December 13, 2017

This letter is in response to the comments regarding AL-17-027, Agritainment, Nelson Winery. The following is the list of comments presented to me that required responses. All required revisions to documents have been updated and resubmitted as well.

SITE PLAN

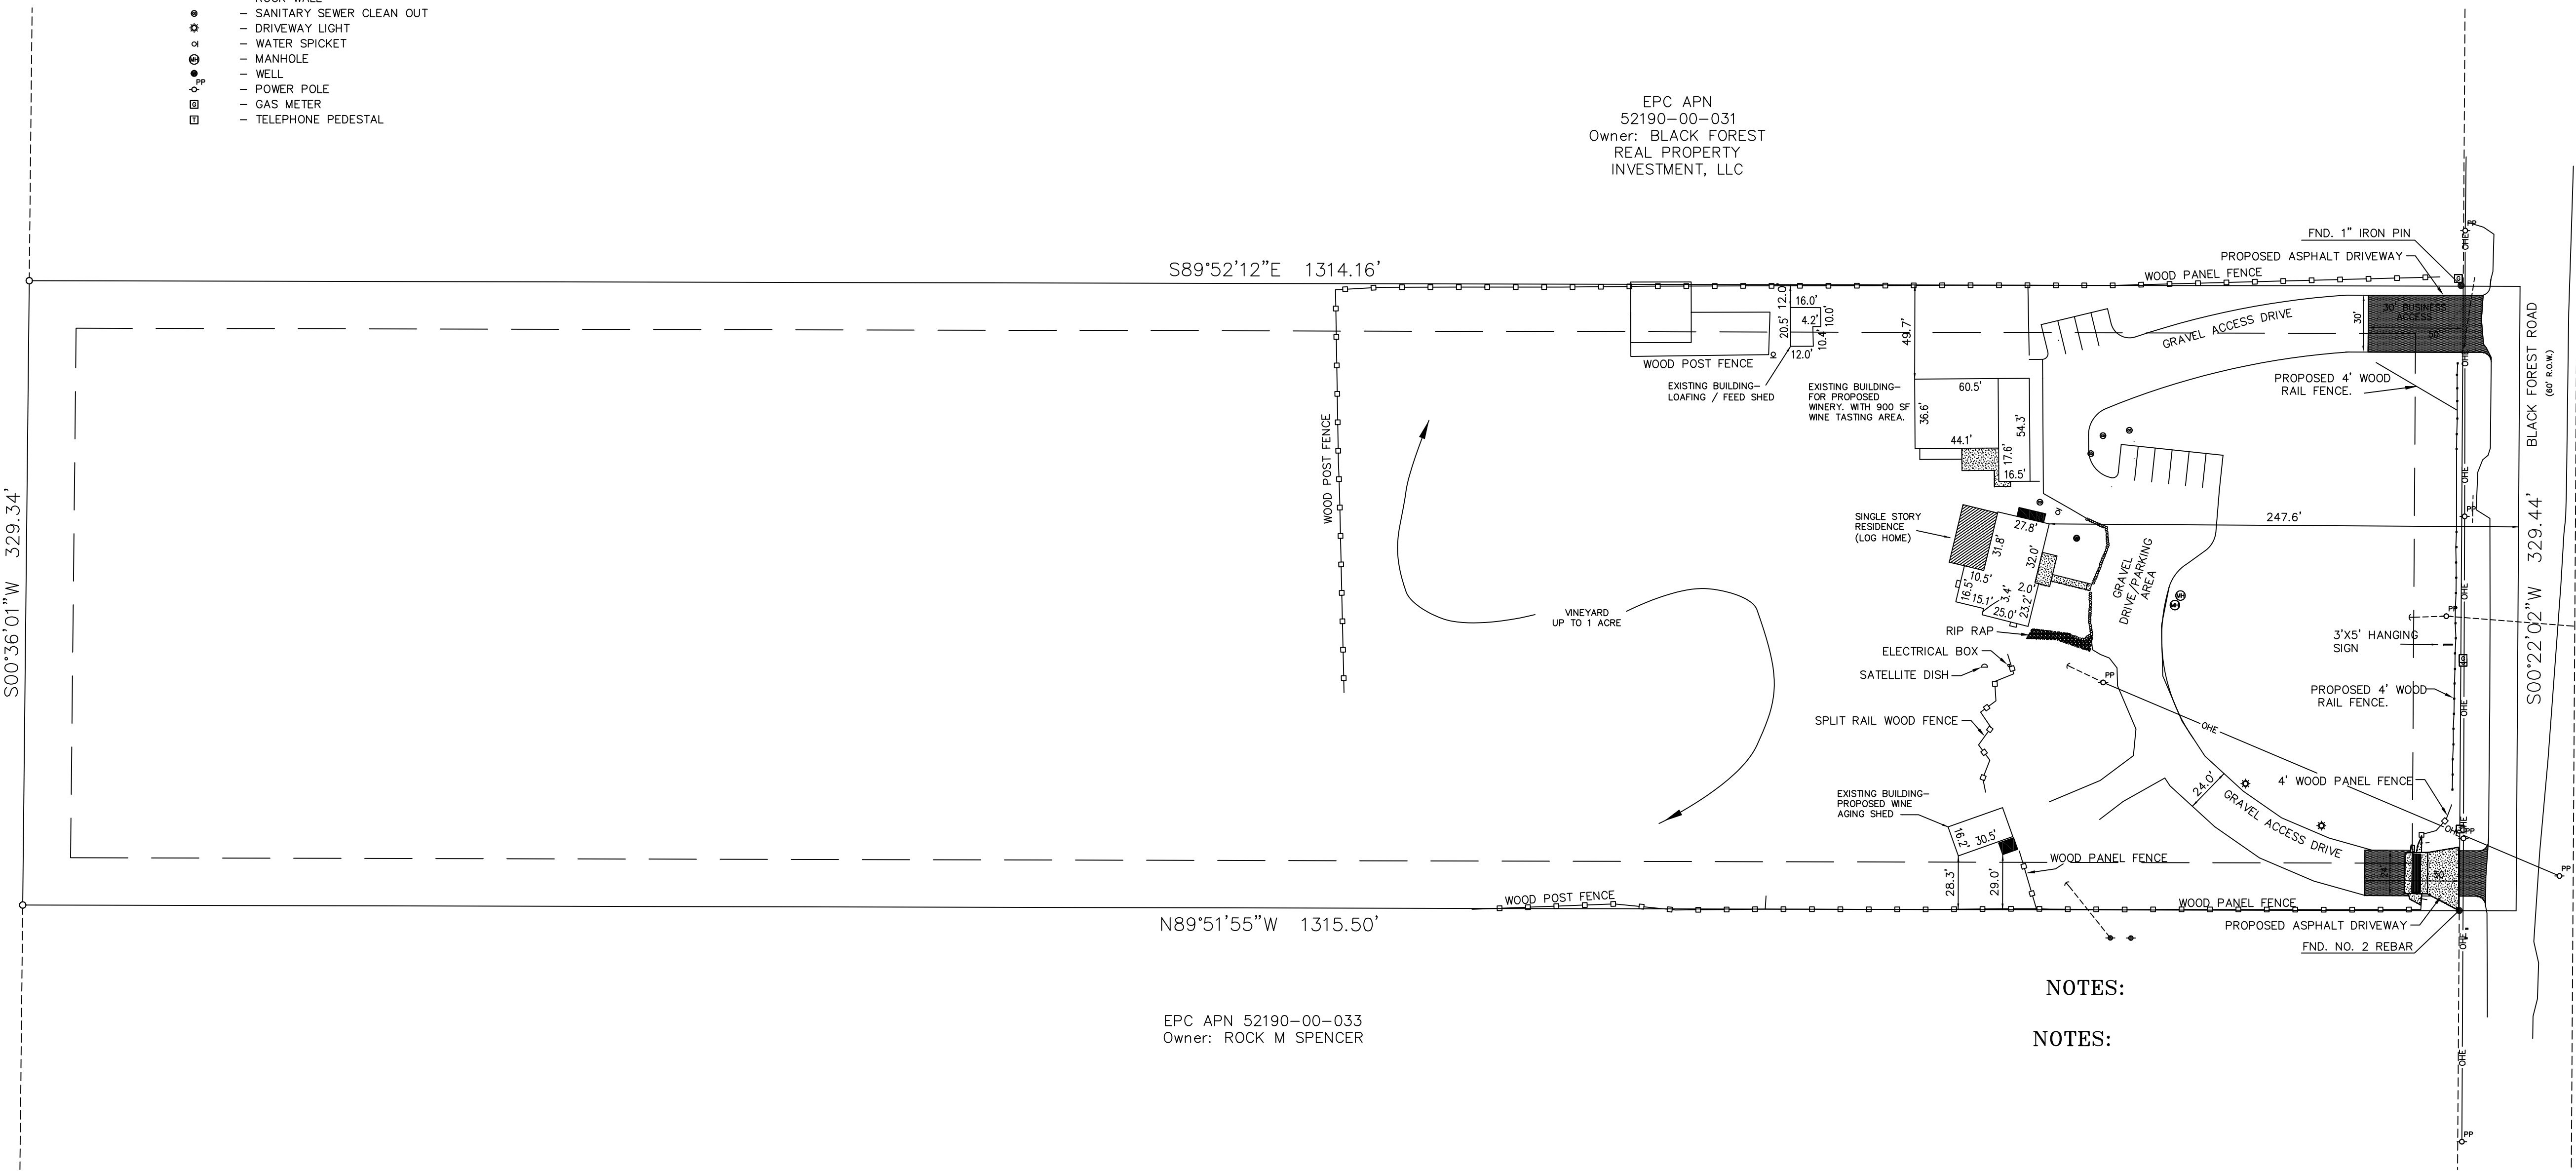
Update the site plan to show the first 50 ft of both driveway access to be paved.

Site plan has been update to show the first 50 ft of both driveways as being paved. Site plan has been resubmitted with this update.

VICINITY MAP
NO SCALE

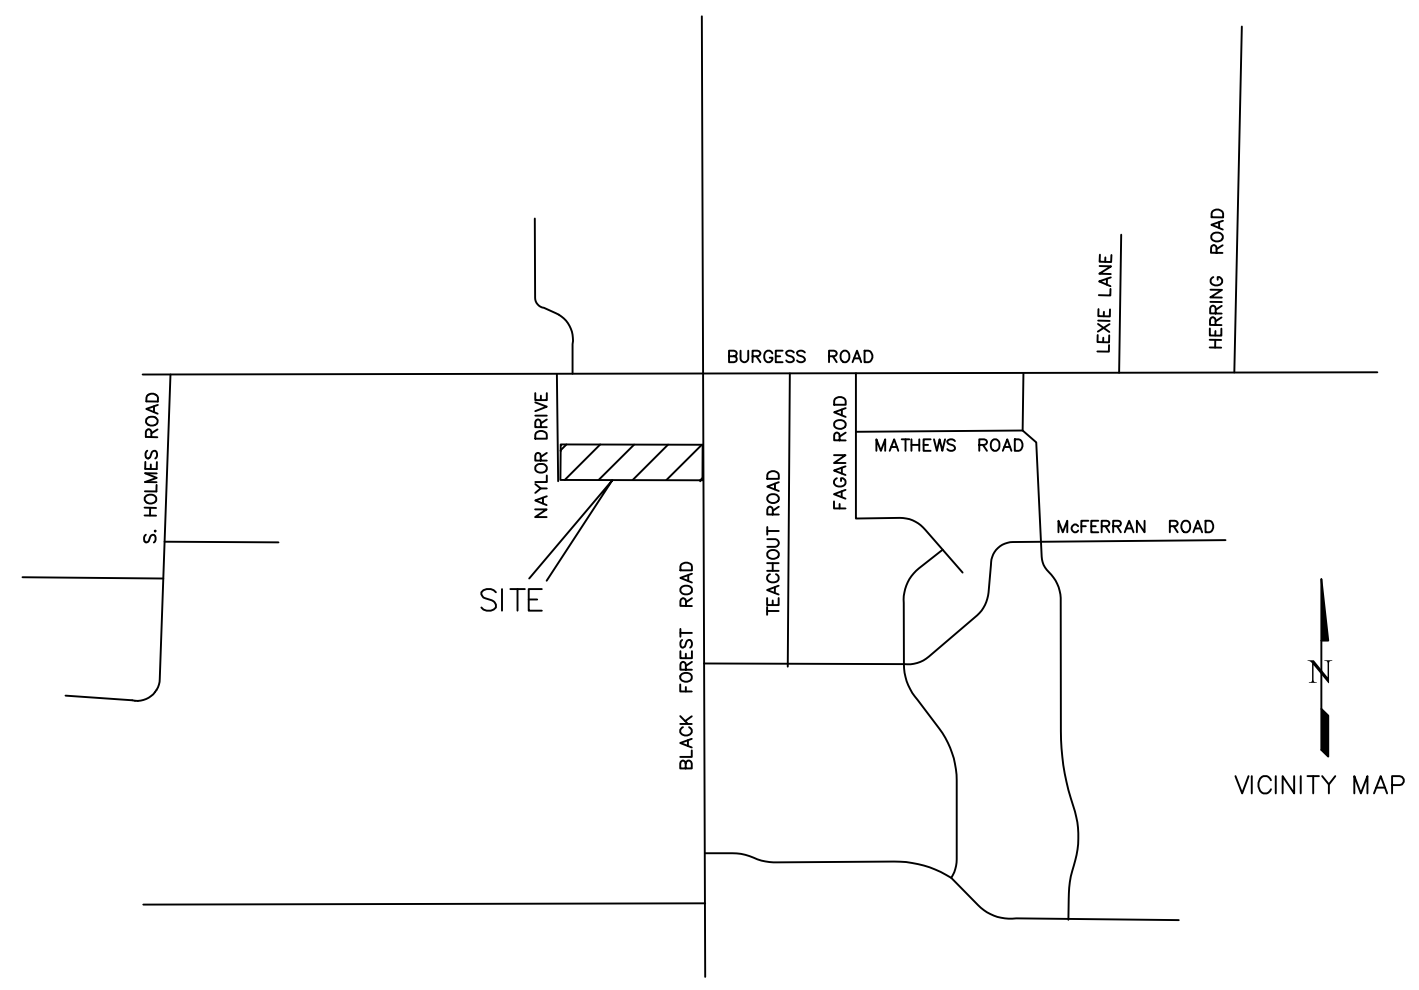
The vicinity map should be resubmitted. It currently shows that your property goes all the way to Naylor Drive, and the parcel map shows there are two properties that are in between Naylor Drive and your property. A map showing surrounding parcels and roads will be necessary.

Vicinity map has been updated and resubmitted.
